Addendum No. 1

RE: Contract # C204370

Pasquotank County (I-6029)

US-17 FROM PERQUIMANS COUNTY LINE TO NORTH END OF US-17
BYPASS.

| N.C. | I-6029 | 1 |

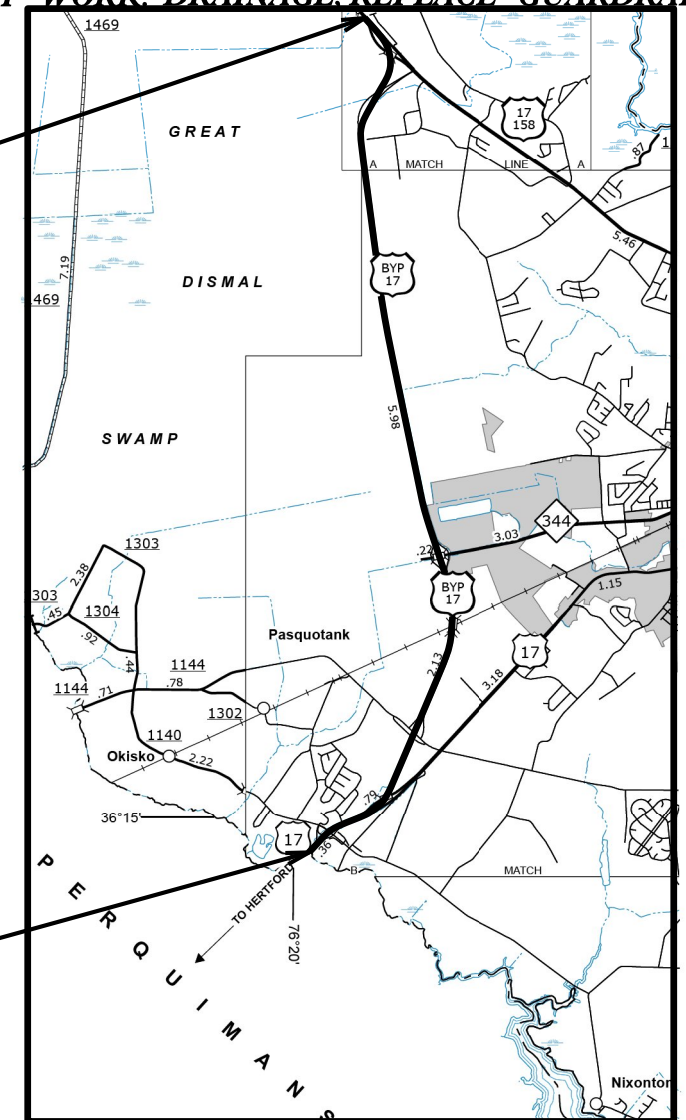
Sheet No.	Revision
1	Notes referencing ramps have been revised
5	Summary of Quantities revised to reflect quantity changes shown below
